July 7, 2015

Mr. Ron Griggs
VALUE BUILD HOMES, INC.
3015 Old Jefferson Davis Highway
Sanford, North Carolina 27332

This report concerns the soils and site investigations on lot 10 in Post Inn Estates located on Old Stage Road just west of Avery Road in Harnett County. The investigations were conducted to determine the area that has been impacted by excavation of soil materials and to propose some remedial measures to render the impacted area usable for a repair area septic system drainfield. Most of the impacted area is in the front yard which is the proposed location for the repair drainfields. The property identification number (pin) is 0588737427.

Project: Lot 10 Post Inn Est.

Site Plan Proposal:  
 118 Bryan Godwin Ct., Erwin, NC

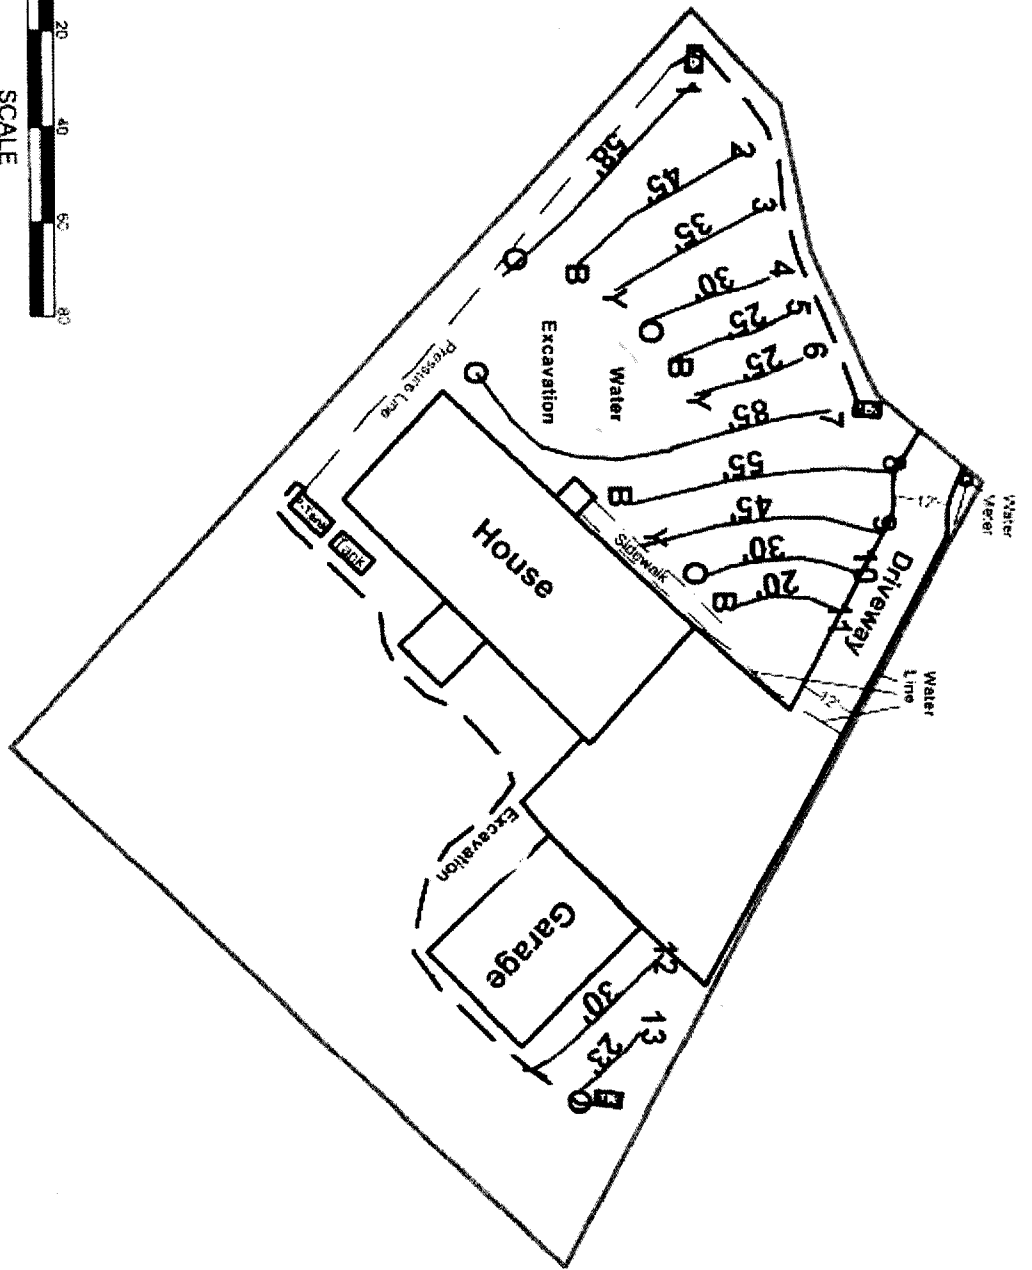
The attached sketch map shows the approximate locations of the existing house and garage as currently located on the lot and a proposed location for the driveway and associated parking areas. This map was prepared using property information and Aerial photography obtained from the Harnett County GIS web site. The topographic contours (2 ft. interval-LIDAR) were obtained from the NC DOT GIS web site.

The disturbed soils areas on the front of the lot are shown as an excavation and water that is ponded in the lowest part of the excavation. The deepest part of the excavation is approximately 2 ft. below the surrounding soil surface in the area of standing water. The edges of the excavation slope outward to the edge. Rough calculations indicate that approximately 50 cu yds of soil materials have been removed from the site. Approximately half of this consists of clay loam subsoil materials.

This excavated area needs to be renovated because it will be necessary to install segments of repair drainfield trenches in the area to accommodate the drainfield as permitted. The excavation needs to be back-filled in a manner that will not drastically alter the functioning of the soil for septic system drainfields. The backfill material needs to have a similar texture as the existing topsoil on the lot. Possible sources for this material would be the soil removed for the driveway and parking pad areas. Also house foundation sites on adjacent lots can also be used as borrow sites. The excavation needs to be properly prepared to receive the fill materials and the fill needs to be installed according to the following plan:

It is my opinion that the above recommendations should provide adequate measures to allow the soils to function properly for repair septic drainfields. An additional recommendation is that the driveway be shifted as far as possible to the left of the front of the lot to allow for a maximum possible area for drainfields on the front of the lot. The driveway as shown on the attached sketch plan meets the requirements of this recommendation.

1. Water as well as the muddy residue needs to be removed from the excavation and the exposed soil needs to allow dry to a moist but not saturated condition. This operation needs to be conducted during a period when there is a low probability precipitation for at least five consecutive days.

2. After drying the soil surface of the excavation needs to be scarified either by discing or manipulation by hand tools to loosen the surface and. The first 4 to 5 inches of fill needs to be incorporated into the underlying surface by discing or by manipulation by hand tools. The remaining fill needs to be installed in a manner to minimize serious compaction. The backfill materials needs to be in a relatively dry condition when installed. It is recommended that the fill be mounded approximately three inches above the excavation to allow for future settlement.

3. The fill surface needs to be stabilized either with sod or by planting a fast growing grass seed variety. It is also important that vehicular traffic be excluded from this area to avoid further compaction.
